Planning Officer: Ms M Tomalova

Planning Application Ref: BN/66/19/PL

Location: Land off Canal Mews Barnham PO22 0DP

Description of works: Erection of 3 No dwellings

Client Seaward Properties Ltd.			
Project Title and Location Land to the East of Barn Rise Barnham			
Drawing Title Tree Retention Protection Plan			
Scale 1:100@A1	Drawn LB	Approved JJ	Date 24.07.19
Drawing No LLD1345-ARB-DWG-002	Revision 01

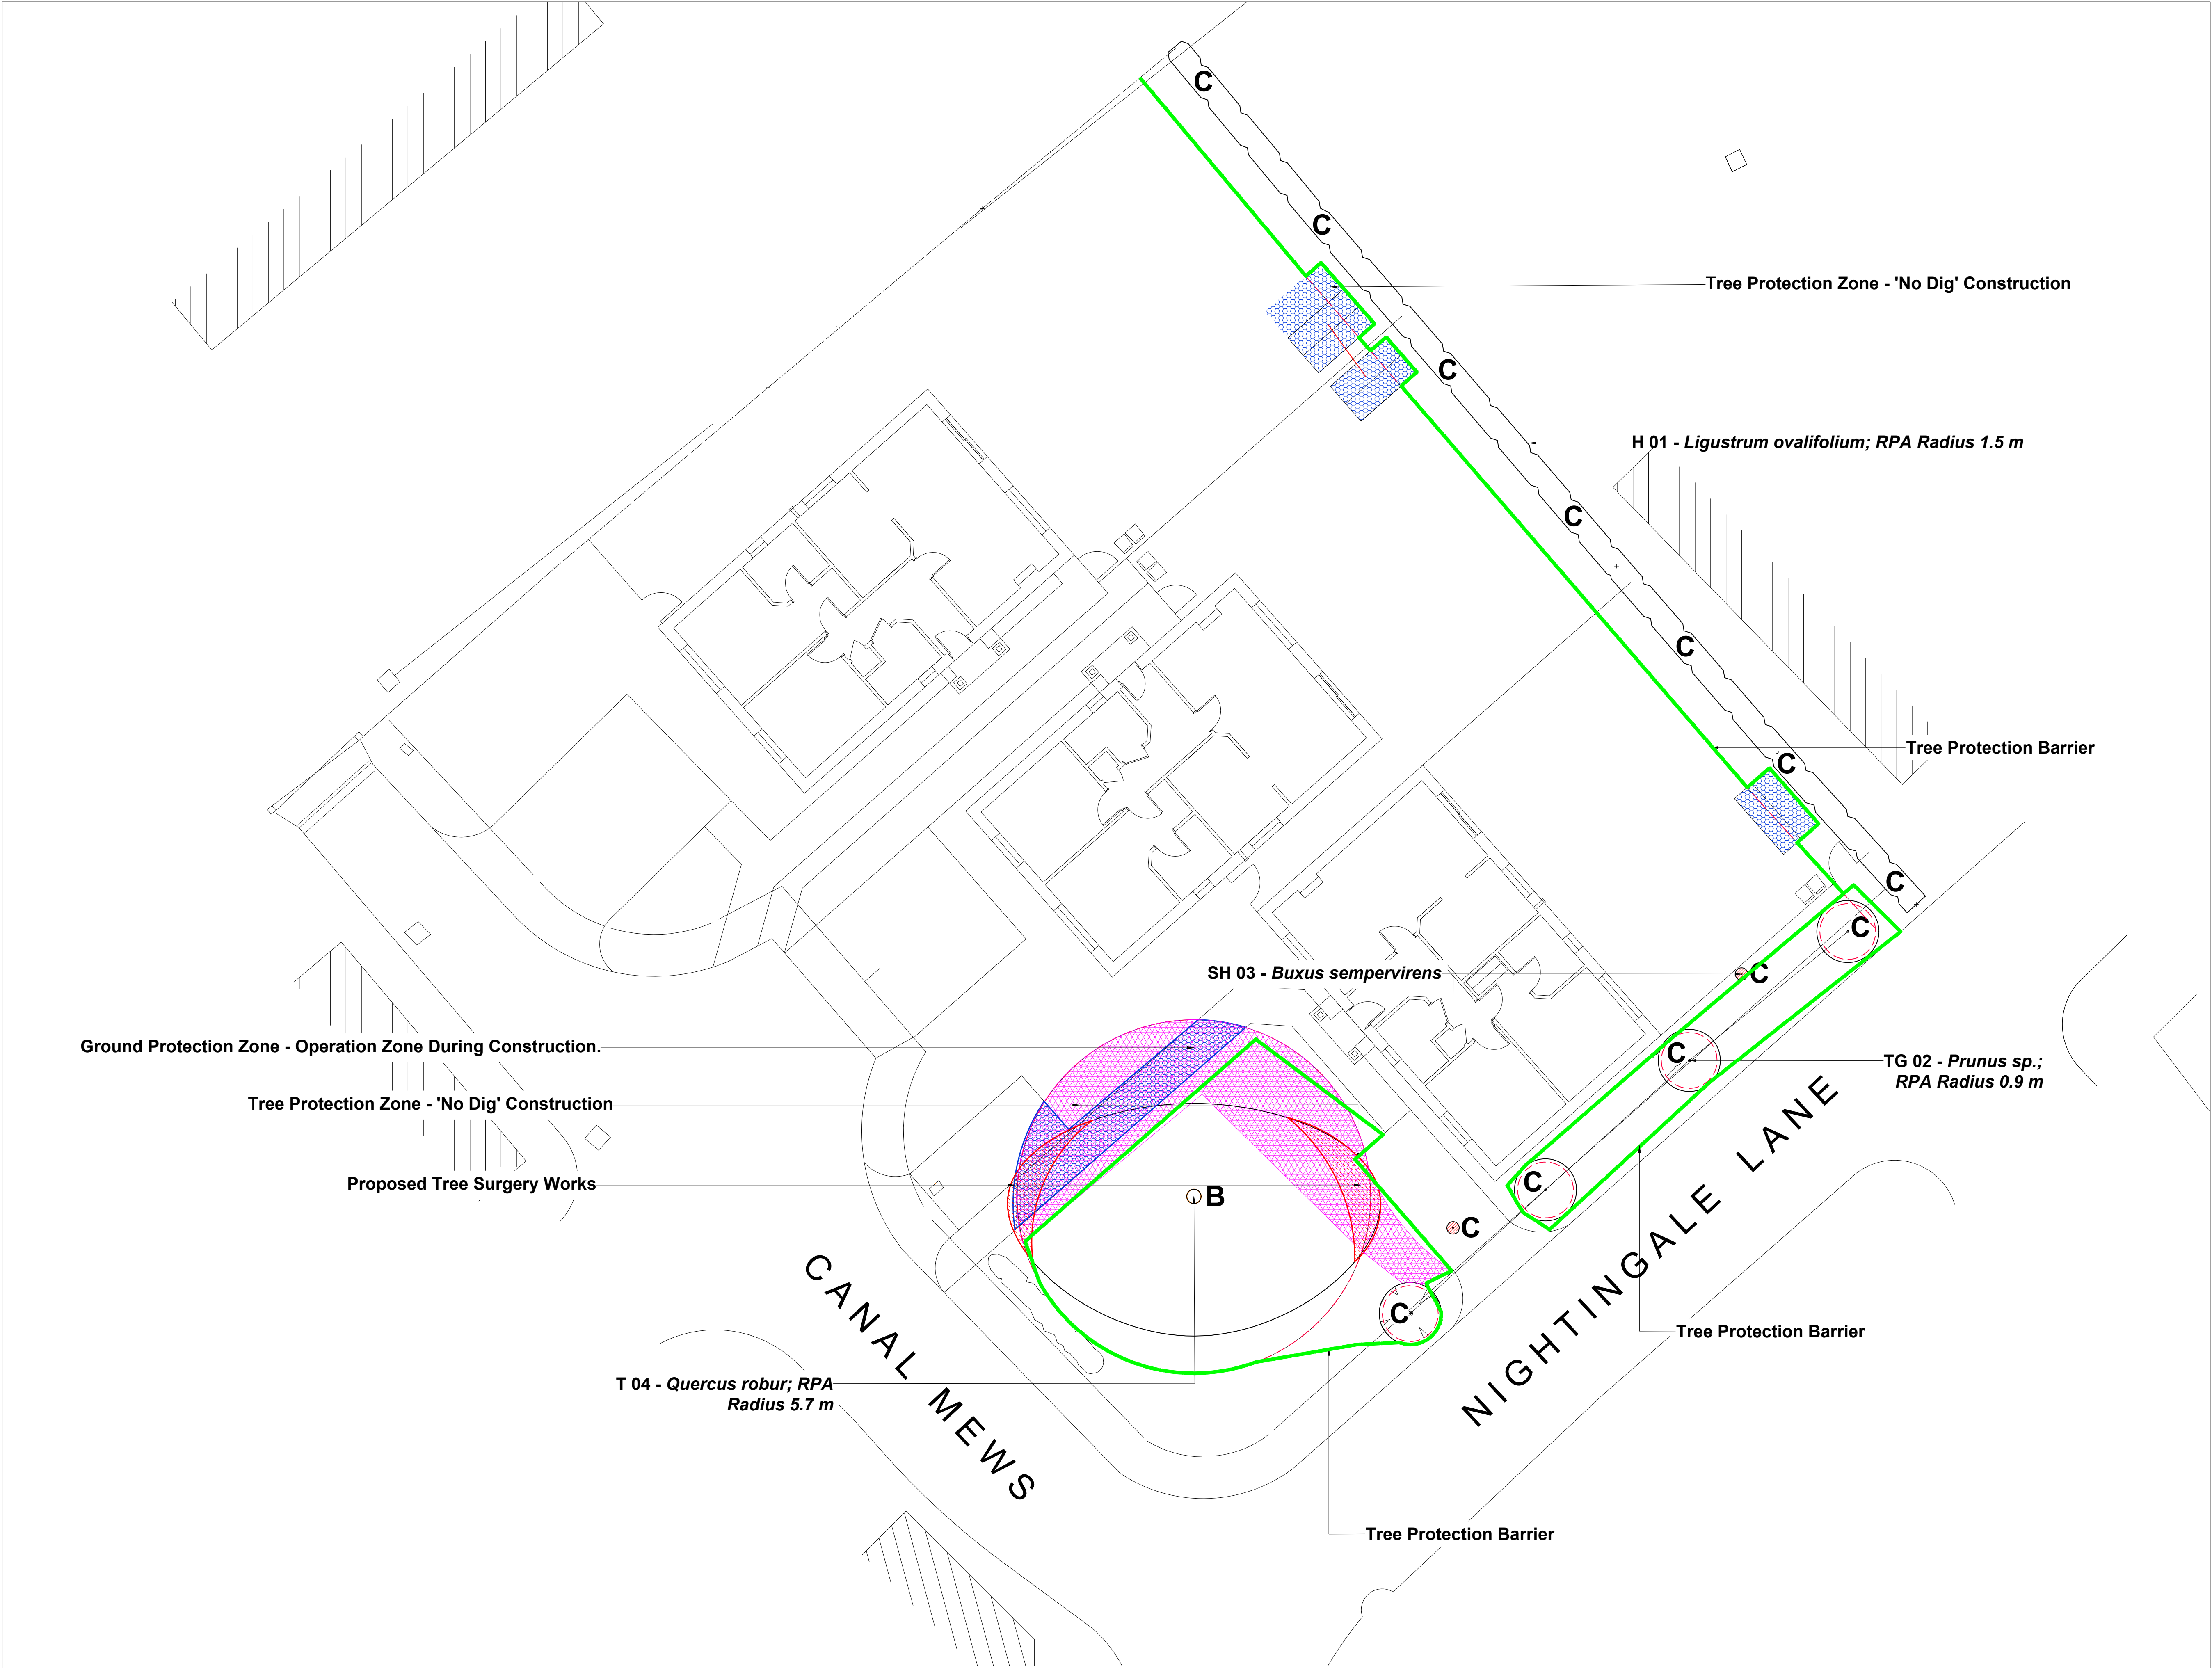
- The current proposed layout is going to impact heavily on the only significant tree (T04 – oak), both above and below ground. Although achievable in principle by adopting the tree protection measures proposed; there is nonetheless a risk that attaches during such incursion of root protection areas. This is especially significant where the tree in question is so prominent, of current high public amenity value, long-term potential and has endured recent ground disturbance/amelioration on remaining aspects.

- Plot 1 is going to experience a high level of seasonal nuisance from the presence of (T04 – oak), which will increase if the tree remains healthy and achieves its current potential.

- The principle of development here is acceptable in arboricultural terms, although there is insufficient appreciation for and consideration of T04's long-term amenity potential and impact on the occupiers of plot 1.
- It seems to me that a determination to provide 3 units will put this tree under excessive pressure and compromise its long-term health and vitality. If the plot layout can be reconfigured or unit quantity reduced so as to leave the nominal root protection area of T04 inviolate – only then would I be able to lend the scheme my support.

- As it stands, I am unable to lend this scheme my support and so register an **OBJECTION**.
- I recommend the making of a Tree Preservation Order in respect of **T04** to preserve its place in the landscape and hopefully better inform a revised layout. I attach a TEMPO form and GIS plan for this purpose.
